COMMUNITY SERVICES DEPARTMENT
PARK OPERATIONS ~ ENVIRONMENTAL SERVICES ~ RECREATION/CULTURAL SERVICES

Subject: Romens Final Plat (SF2226)

The Community Services Department has reviewed the Romens Final Plat application and is providing the following preliminary comments on behalf of El Paso County Parks. This application will be presented to the Park Advisory Board on September 14th and its recommendation will be provided after the meeting.

FINAL PLAT

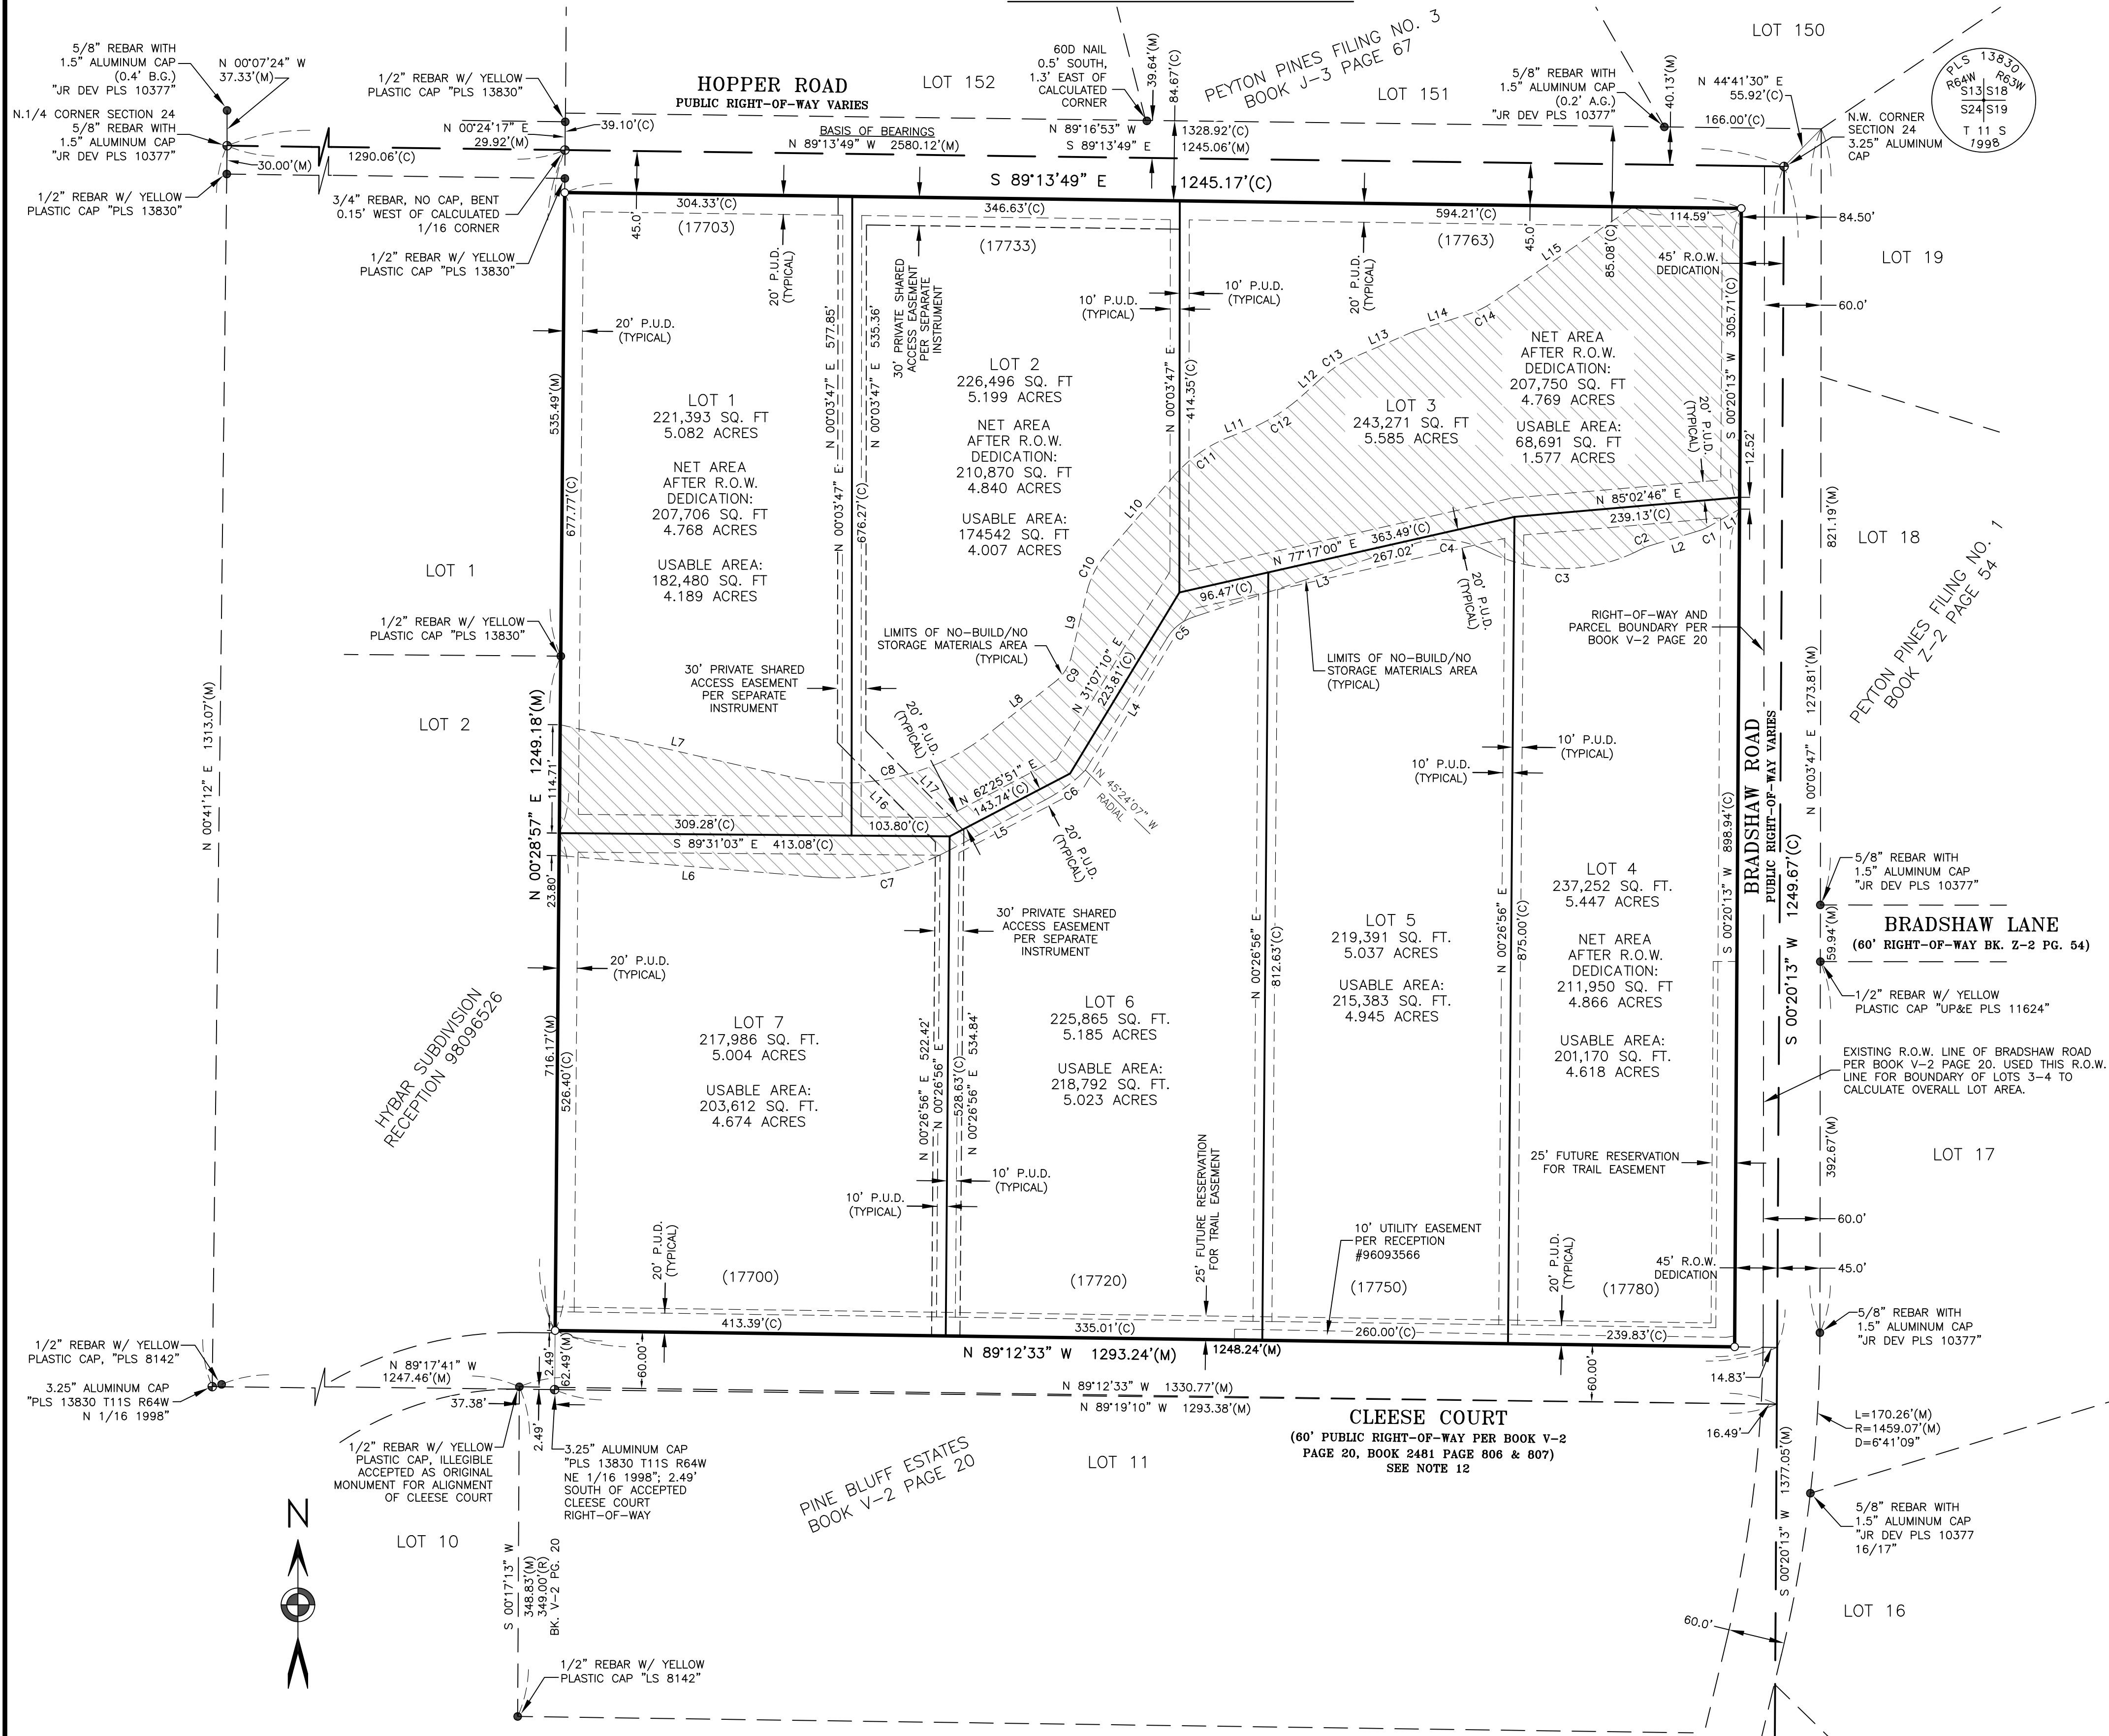
County Parks requests trail easements where development projects impact proposed County trails. As it pertains to this application, the County requests that the landowner provide a 25-foot-wide public trail easement along the south side of the development, outside the drainage and utility easement, and from the SE corner of the development north to the intersection of Bradshaw Lane that allows for the construction and maintenance by El Paso County of the Palmer Divide Regional Trail.

The Park Advisory Board recommends that the Planning Commission and the Board of County Commissioners include the following conditions when considering and/or approving the Romens Final Plat: (1) designate and provide to El Paso County a 25-foot-wide public trail easement along the south side of the development, outside the drainage and utility easement, and from the SE corner of the development north to the intersection of Bradshaw Lane that allows for the construction and maintenance by El Paso County of the Palmer Divide Regional Trail, and dedicate the easement to El Paso County prior to the recording of the Final Plat (2) fees in lieu of land dedication for regional park purposes in the amount of \$3,220 will be required at the time of the recording of the forthcoming Final Plat.
